Recommendation Report for Lawful Development Certificate for a Proposed Use or Development**REF NO:** EP/44/22/CLP**LOCATION:** 2 Vicarage Lane
East Preston
BN16 2SP**PROPOSAL:** Lawful development certificate for a proposed new close board fence at varying heights to be built along boundary of site within the current brick dwarf wall.**DESCRIPTION OF APPLICATION**

The application seeks a Lawful development certificate for a proposed new close board fence at varying heights to be built along boundary of site within the current brick dwarf wall.

GA 007

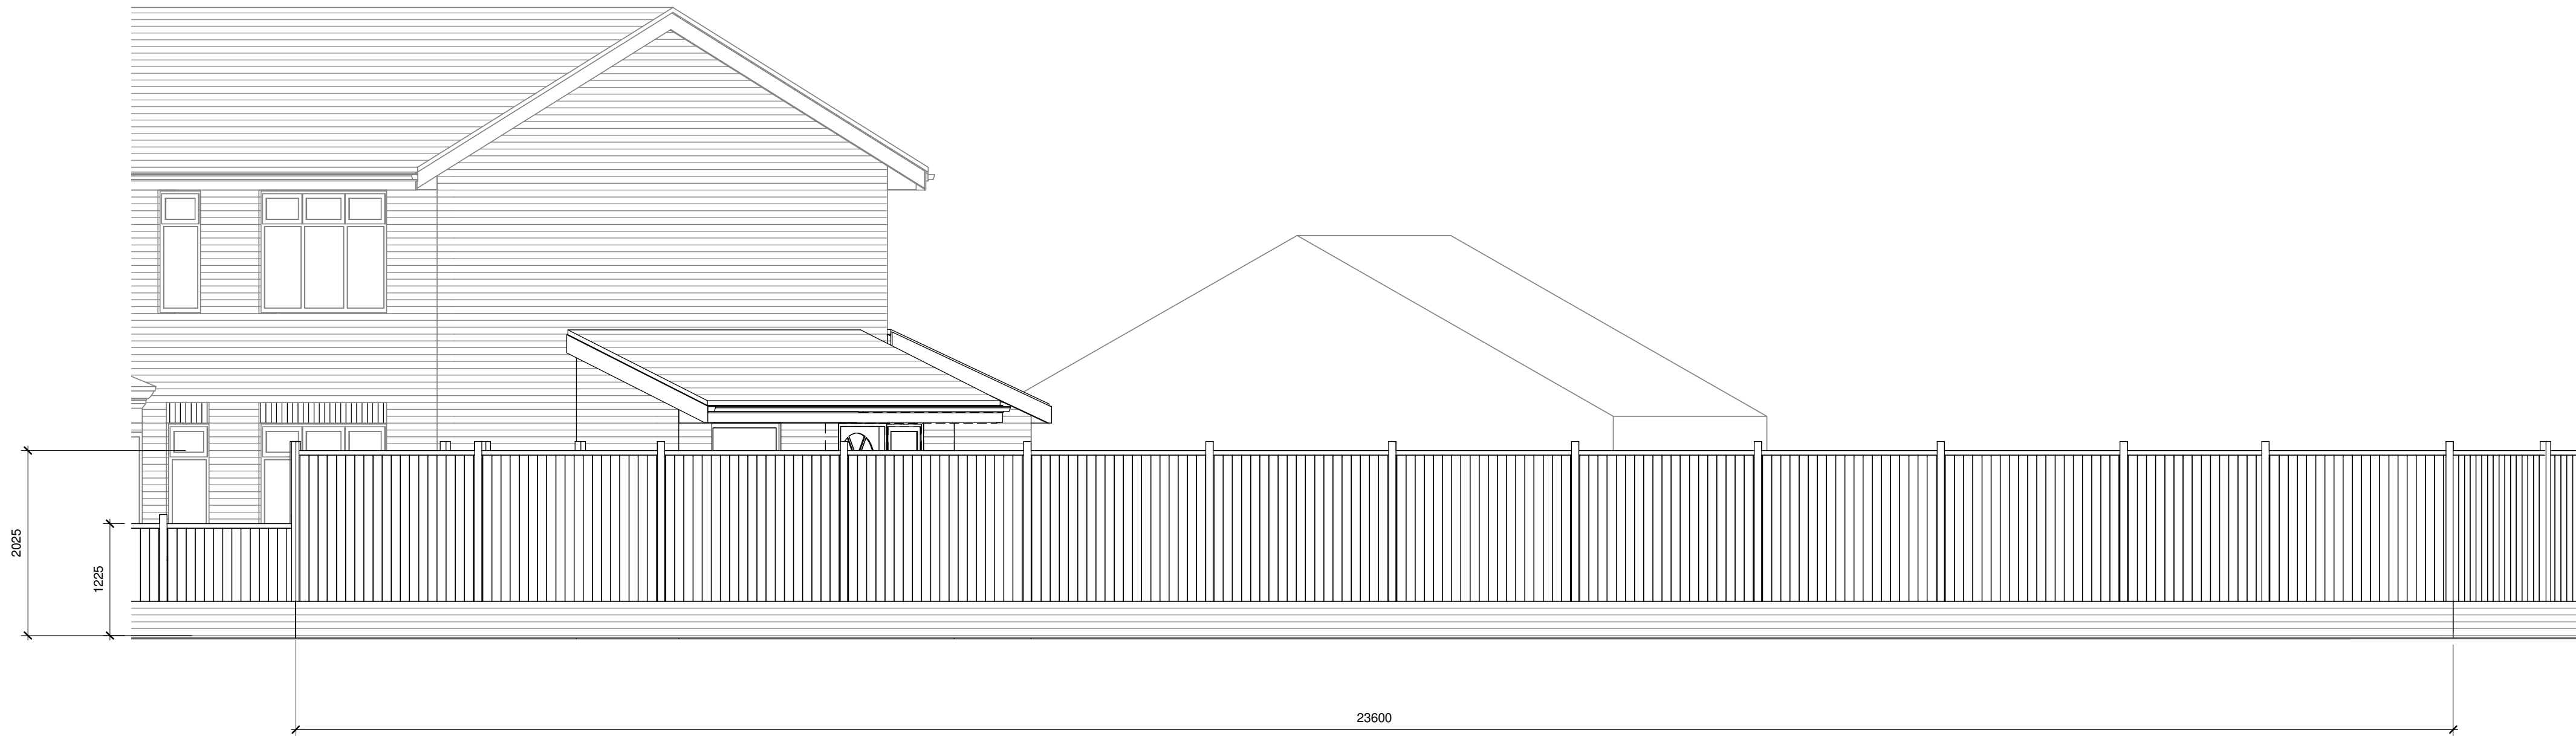
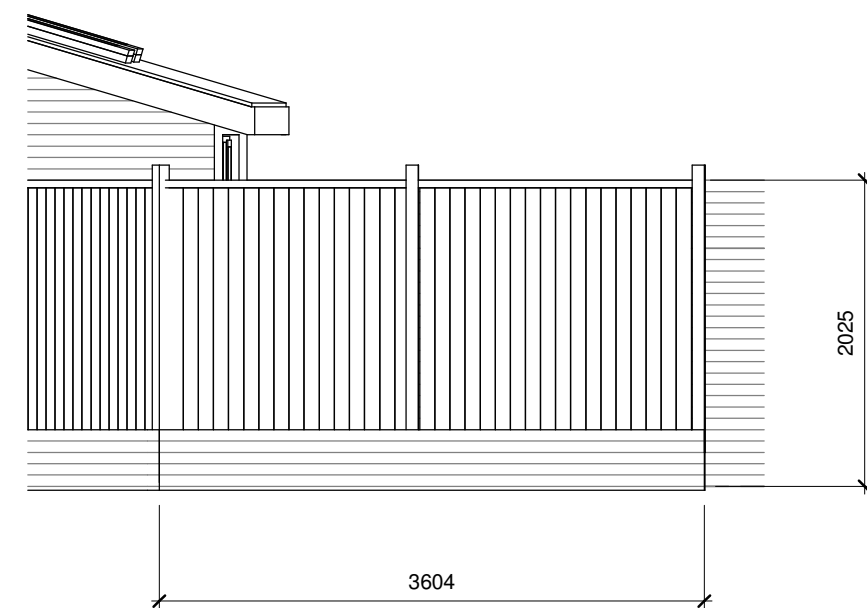
The part of the fence to the front of the site is considered adjacent to the highway and is over 1m in height. The applicant suggests it is not adjacent and quote an appeal case in their favour. Due to the layout of the road, which features relatively wide grass verges the proposed fence would appear adjacent to the highway in this instance in conflict with A.1 (ii). Further part of the proposal does exceed 2m in height (proposed at 2.025m high). This does not comply with relevant section A.1 (b) and is not considered permitted development and as such requires the submission of an application for full planning permission.

The proposed fence does not fall under Schedule 2, Part 2, Class A of the GPDO.

Construction of a close board fence at varying heights of 1.225m and 2.025m to be built along boundary of site within the current brick dwarf wall.
